From: planning
Subject: FW: 2 Warwick Drive Clitheroe
Attachments: BB177- 2 Warwick Drive_MODEL_v_1_Sent to Walter-BB177-100_Existing Plans....pdf;
BB177- 2 Warwick Drive_MODEL_v_1_Sent to Walter-BB177-200-B_Proposed
Pla....pdf

I noticed your response to our application for a residential extension to 2 Warwick Drive.
Planning Application No: 3/2017/0557
Grid Ref: 374774 442577
Proposal: Two storey extension to the side.
Location: 2 Warwick Drive Clitheroe BB7 2BG

Roof/Site Plan

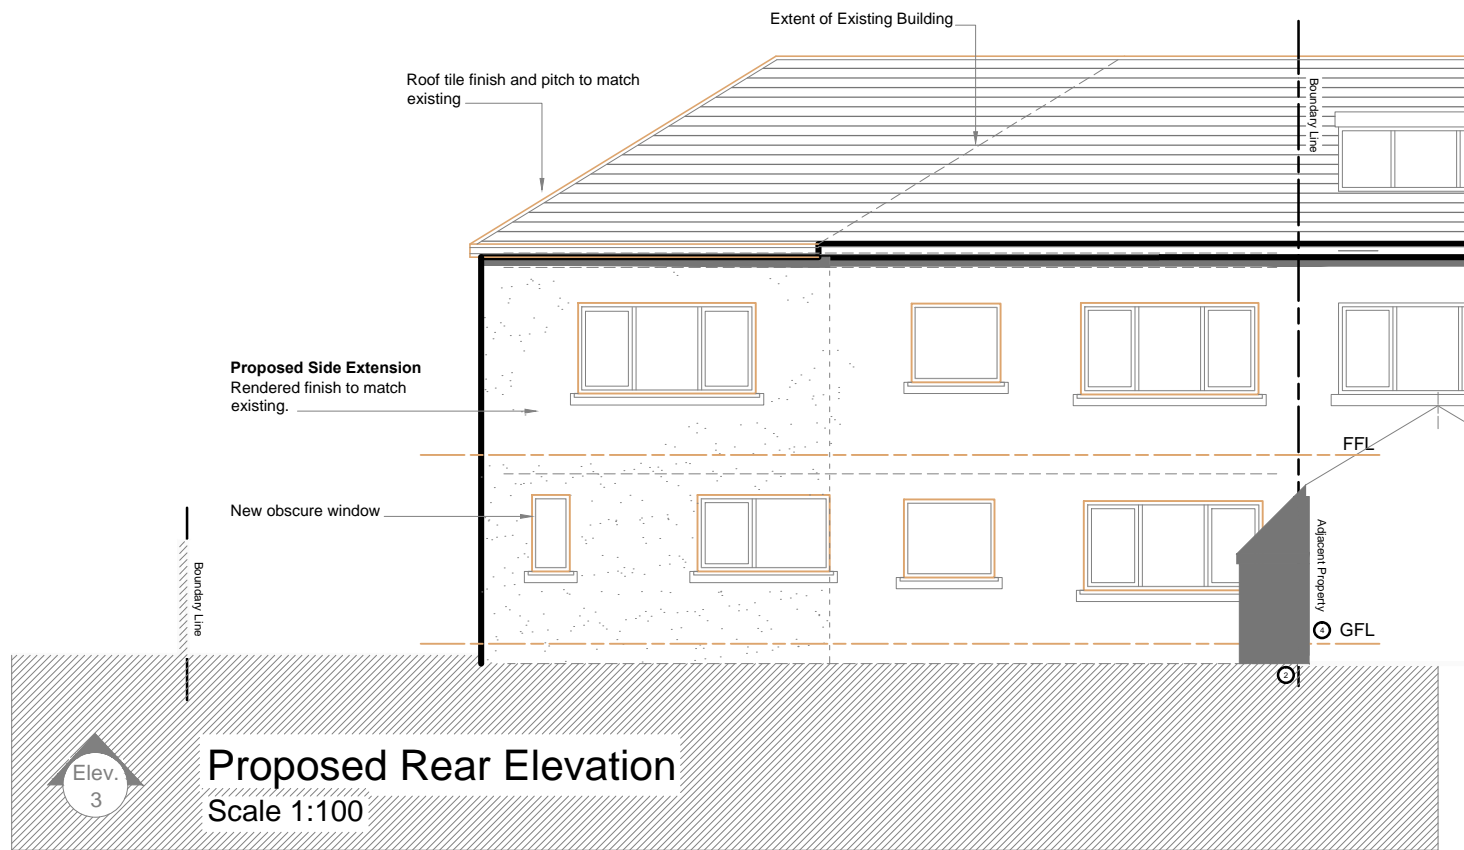
With regard to the updated plans for parking at 2 Warwick Drive, Clitheroe post completion of the two story extension to the property. I can see that the revision Indicates that the present vehicle crossing will be used for all three parking spaces and as much as this is totally acceptable I would have preferred the original submission to be adopted as this would of allowed each vehicle to be used independently. The revised parking plan dose rely on one vehicle being moved before the other two can be used.

Please find attached revised plans which show that the existing driveway can already accommodate 3 cars.

On this basis, please could you consider withdrawing your request for a condition to be attached with a requirement to extend the dropped kerb?

If the developer does decide to use the revised plans then there will be no need for notes and conditions as outlined in the previous message.
